I make the following submission in regard to the Environmental Impact Statement for the State Significant Infrastructure – Northern Beaches Hospital Application (SSI 5982).

I direct my submission in particular to Appendix 'C' of the "Traffic and Transport Impact Assessment" prepared by Hyder Consulting as part of the Environmental Impact Statement for the Concept Proposal.

Figure 5: Indicative Proposed Site Vehicle Access Arrangements (Note: Indicative Site Layout)

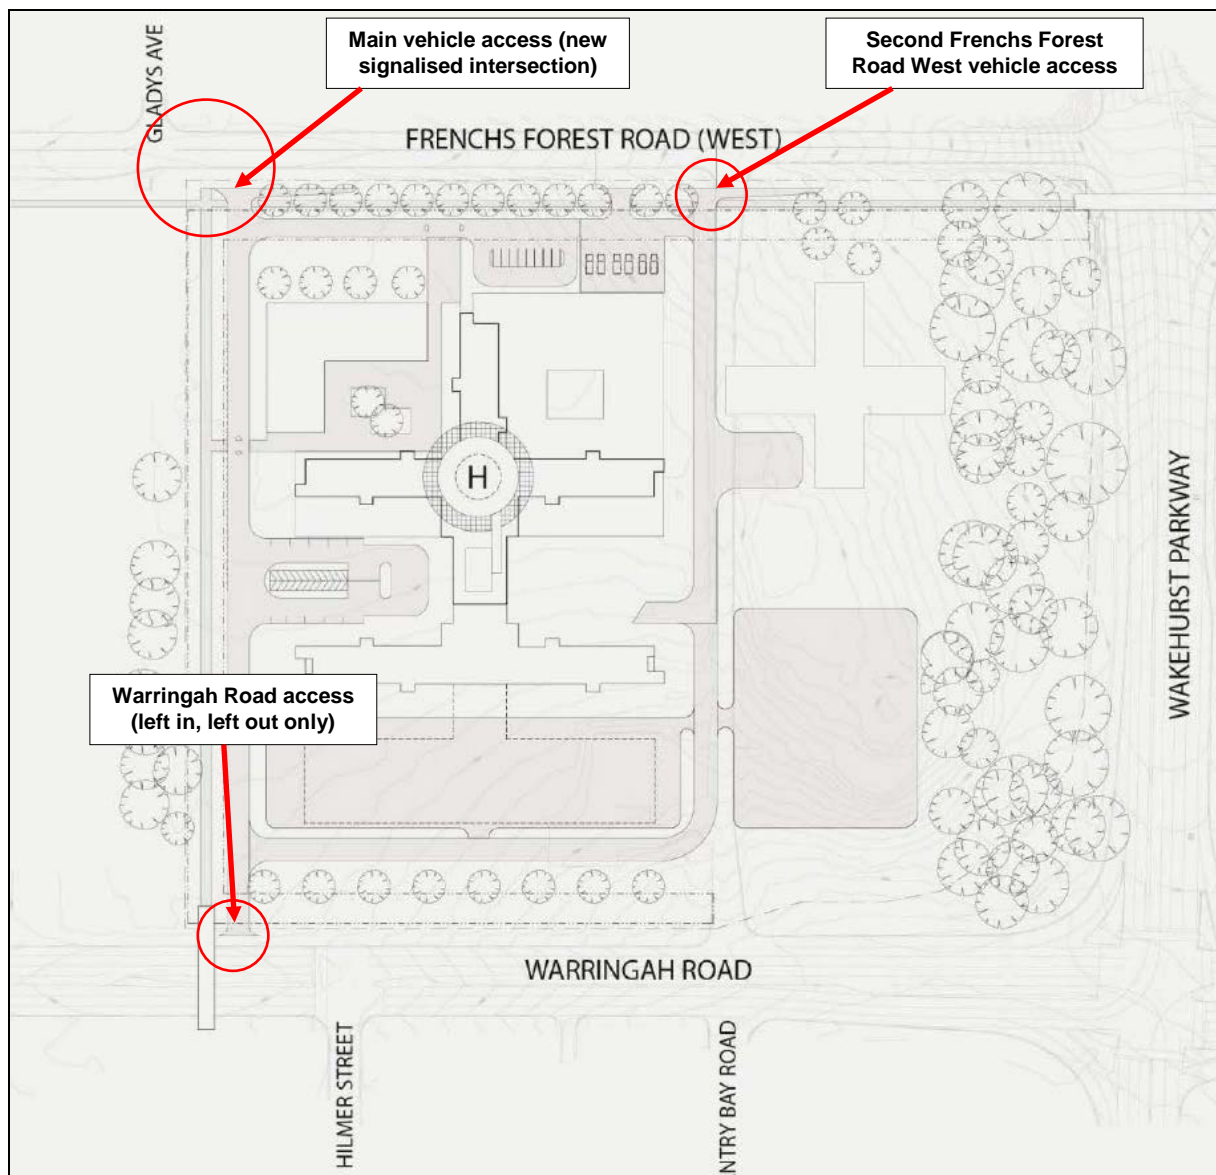
Section 4.8 proposes that two main entrances occur in Frenchs Forest Road (West) at intersection with Gladys Avenue, and also at a point at least 65 metres to the East.

“This is directly at the junction with the Forest High School, and in a 40 k/h school zone. This is a highly questionable location for a major hospital entry/exit, being as it also requires ambulance access, and is likely to have 900 outbound trips per hour generated in peak hours (stated in the assessment) – this also being school arrival/departure times – (school buses, large 4W drive vehicles). This is compounded by the high traffic flow along Frenchs Forest Road (West) normally, which will increase by virtue of the ‘diversion’. “

“A further consideration in this potential disaster is that traffic flow from the North on Wakehurst Parkway surely must be allowed to turn right at the intersection with F.R. Road (not currently permitted), providing even more traffic volume. This right turn is essential of course as it offers the only access for traffic from the North to the hospital’s main entrance, although periods of closure of the Parkway is another problem. Suggestions that there is some capacity in midblocks is also absurd.”

Section 4.8 also proposes that a southern entrance/egress point would be provided on Warringah Road around Hilmer Street (left.in.left.out), and with right-turn access for emergency ambulances.

“This would provide entrance for general traffic only from the West – a fact which amplifies the point previously that traffic from the East will use Frenchs Forest Road (East). Signalised intersection at Hilmer Street already existing would need to be adjusted to allow ambulance right turn – another delay to traffic flow.”
